A303 Sparkford to Ilchester Dualling Scheme TR010036

8.8 Draft Statement of Common Ground with Defence Infrastructure Organisation

STATEMENT OF COMMON GROUND

Version	Date	Status of Version
Rev A	January 2019	Draft for Deadline 2

WORK NO.29 - POND 4 (SECTION 4A)

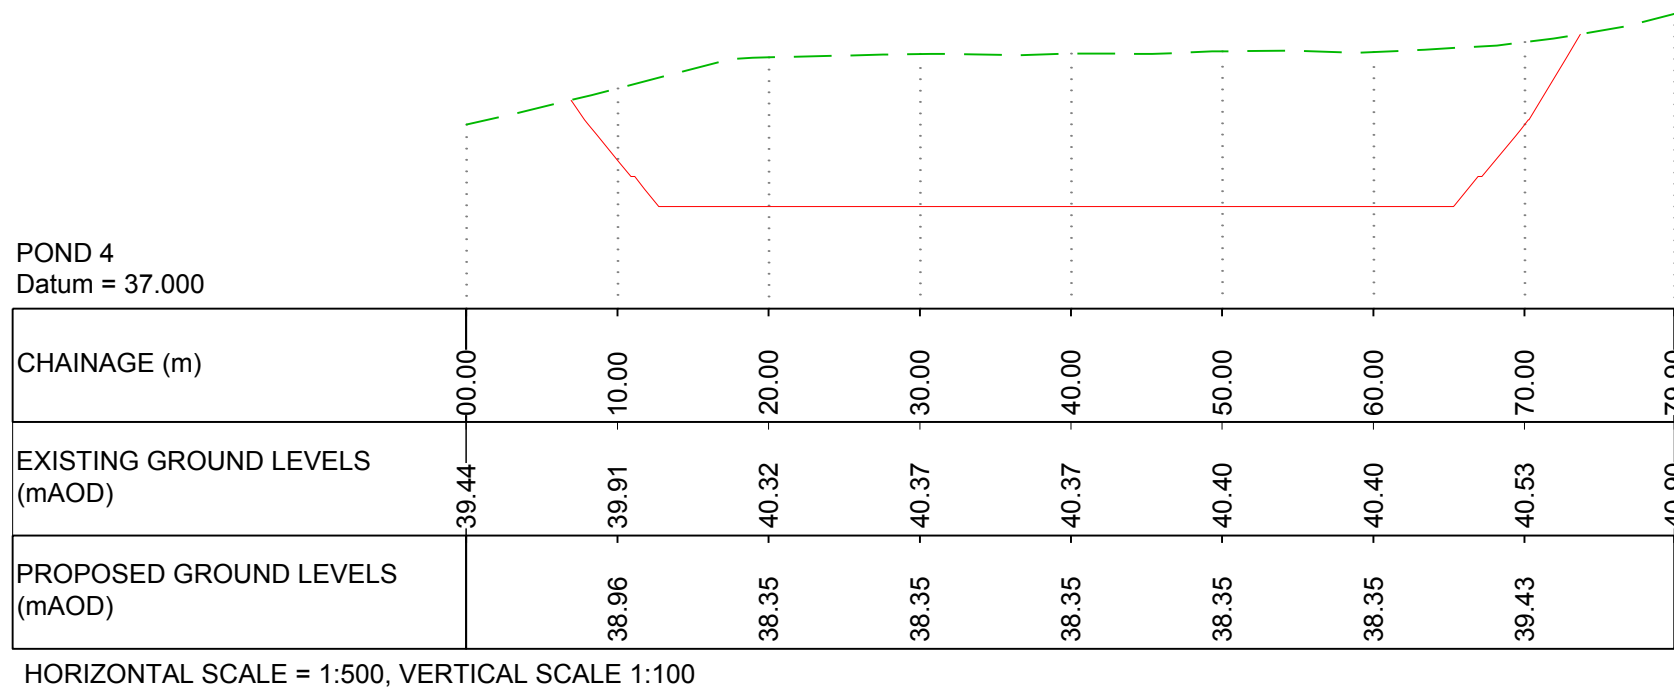
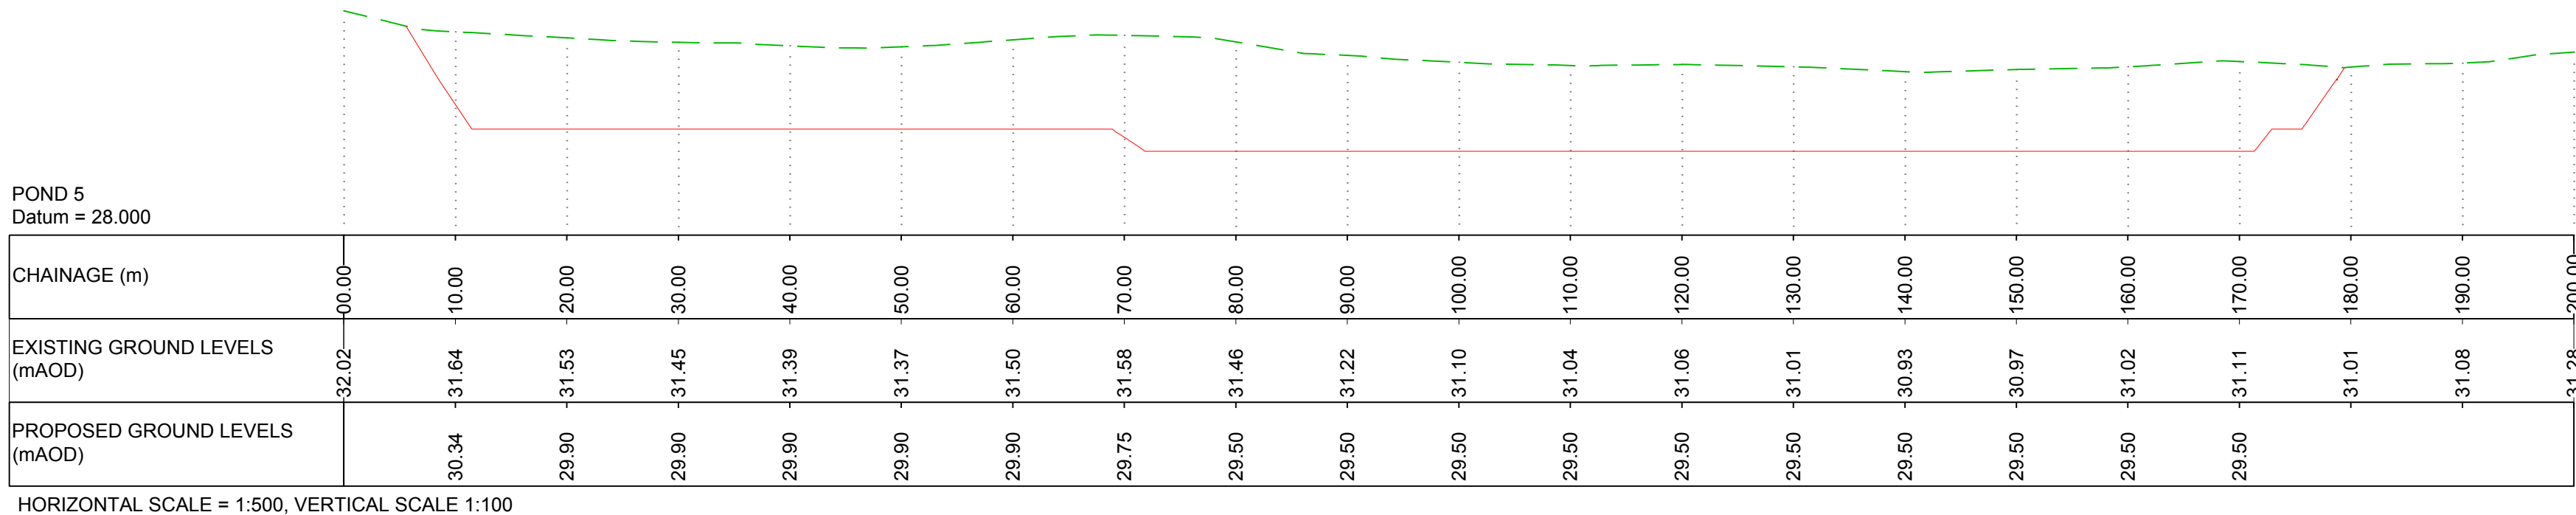
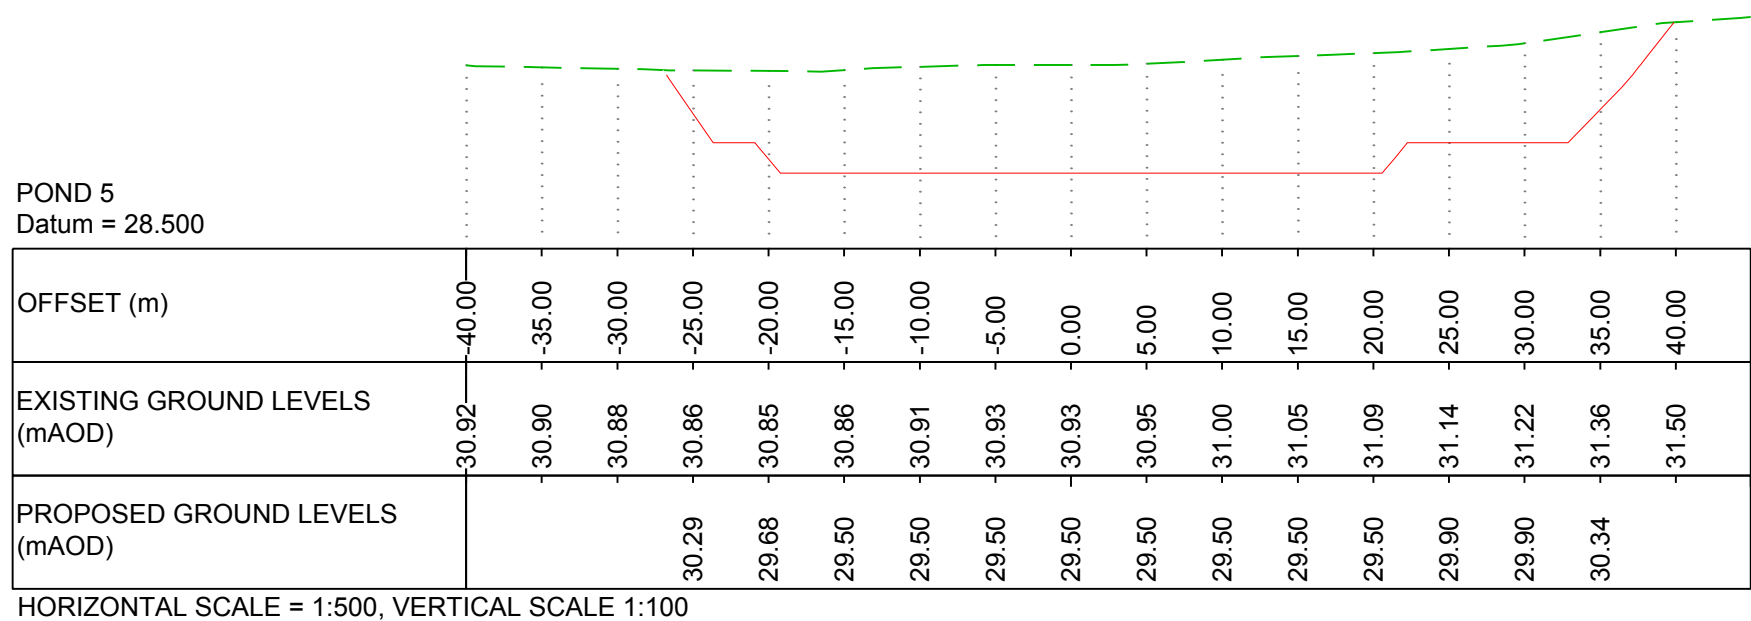
3.3.3 These ponds are generally sheltered and do not provide open views of the countryside except for the pond 4 that has open views to the south.

- There are limited records of problem bird species in the area;
- Ponds are generally sheltered apart from pond 4, which may require some additional measures.
- Adjacent road noise is likely to deter birds; and
- There will be no public access to these ponds to eliminate possible bird feeding.

- The planting adjacent to Pond 4 will be reviewed.
- Further discussion with the DIO's bird-strike safeguarding team would be useful.
